Re: Brunel University Sports Centre Plant - Ref 74314/APP/2023/2733

PLAN OF FIRST FLOOR TERRACE WITH MECHANICAL PLANT

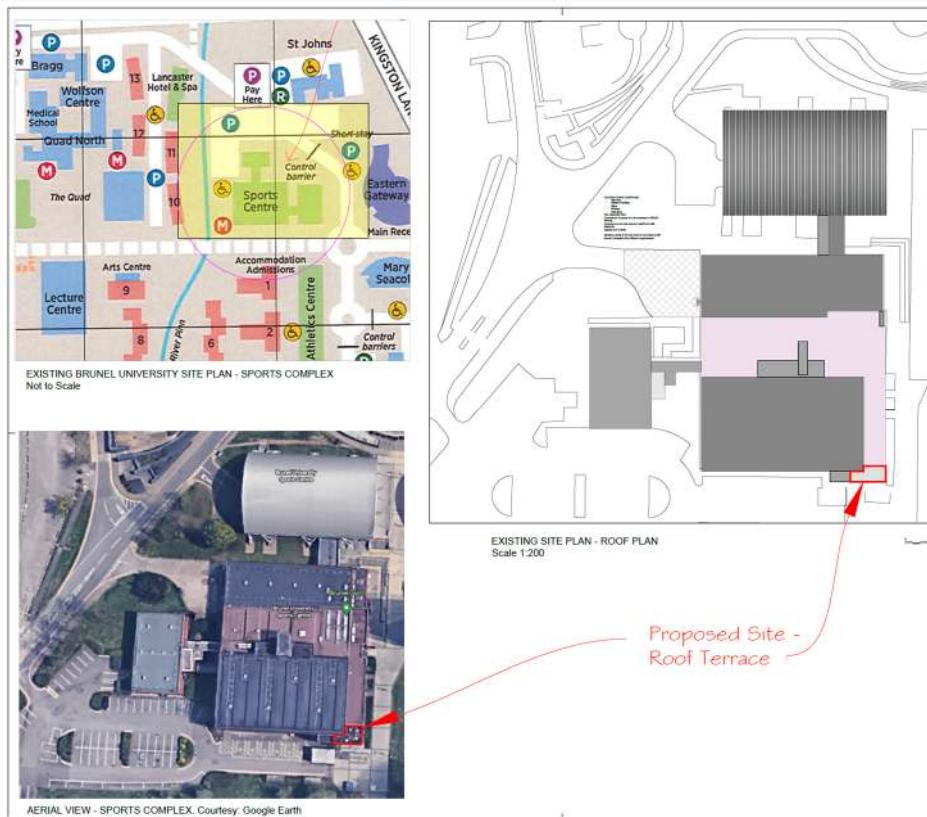
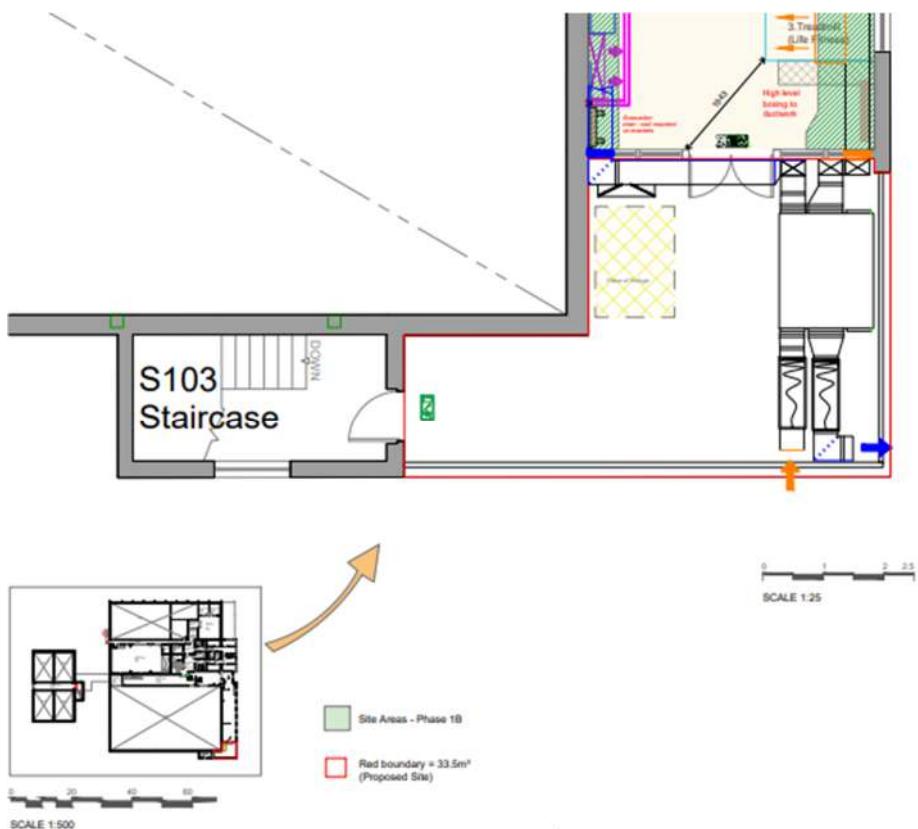
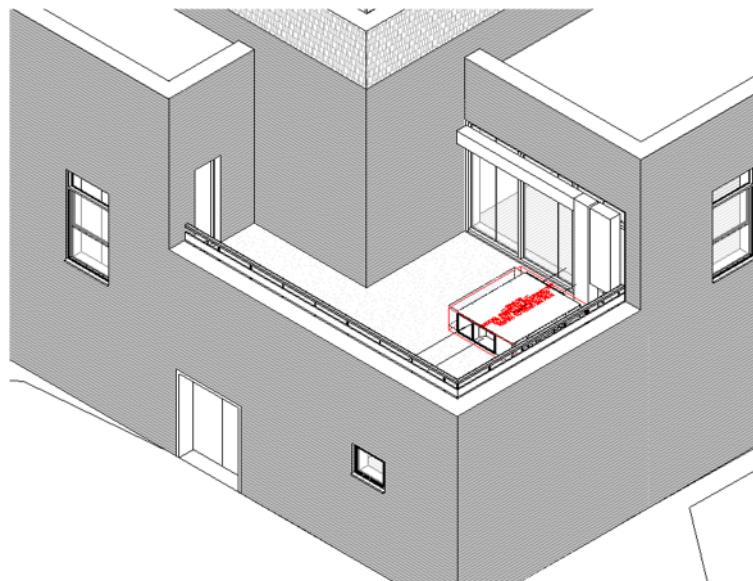
1. **HILLINGDON URBAN DESIGN COMMENTS:** “..The proposed ducts are large and very visible, both from (sic) internally and externally. The proposed siting would reduce the amount of clear view through the glazing by about half.....”

2. **HILLINGDON URBAN DESIGN COMMENTS:** “....This is largely avoidable and not acceptable. The proposals should be amended to reduce the visual impact. The following sketch indicates a potential option, as described below..”

3. **HILLINGDON URBAN DESIGN COMMENTS:** “... The horizontal duct should be located internally, or externally, but higher, above the windows, to retain the full unobstructed window height...”

4. **HILLINGDON URBAN DESIGN COMMENTS:** “.....the two vertical ducts could be placed in the other corner, ideally internally, or otherwise against the wall, where they could be hardly visible externally and obstructing the view to the outside....”

- a. **UNIVERSITY TEAM RESPONSE:** The brief is to situate a gym exclusively for the ladies of Brunel University in order to be inclusive of their cultural and religious needs. The intention is to provide blackout film on all fixed glazing such that there would be no clear view through the glass panels. The double escape doors will have obscure film to the inside therefore none of the proposed ductwork or plant will be visible from the Gym side.

- b. The ducts are sized based on the size of the space and anticipated occupancy based upon design good practice and in accordance with The Chartered Institute of Building Services Engineers recommendations. To say the ducts are large is subjective as the ducts are correctly sized to transfer the level of ventilation required.

- a. **UNIVERSITY TEAM RESPONSE:** The design is a mechanical services solution for the ventilation requirements to meet the Building Regulations. As it is a specialist field, D&K as architects, surveyors and designers have deferred to the expertise of mechanical services engineers who are best qualified to guide and advise as to possible solutions. The alternative solution put forward is not practical with commercially available equipment and any change from the proposed design would require two units to meet the ventilation requirements and highly likely to impart a greater level of visual impact.

- a. **UNIVERSITY TEAM RESPONSE:** The size of the duct has been given by the manufacturers of the air handling unit. It has been sized for its required performance. The ducts will have to pass under the lintels to the windows, and travel across to both ends, with as little bends in the path. As such, it will not be possible to retain the full unobstructed height as suggested as this requires cutting the ducts through the brickwork penetrating the roof structure.

- a. **UNIVERSITY TEAM RESPONSE:** The AHU system requires outlets at low level to input fresh air and discharge extracted air. Ducts in the other corner will obstruct the path to the Fire Exit which will contravene Building Regulations and Fire Safety Regulations.
If the ducts are relocated into the other corner, e.g same corner, the supply and extract ducts would need to run one above the other. This results in the ducts taking up considerable wall space which is undesirable but more importantly presents a short circuit between the supply and extract thus negating the best performance from the air provided.

- b. The Heat Recovery Unit will have to be split into two units to be situated vertically against the wall and the size will not be smaller, and it will still be visible, thereby defeating the purpose of embarking on such an exercise. Essentially doubling the size of the units that would have to be wall hung, resulting in a far more noticeable installation.
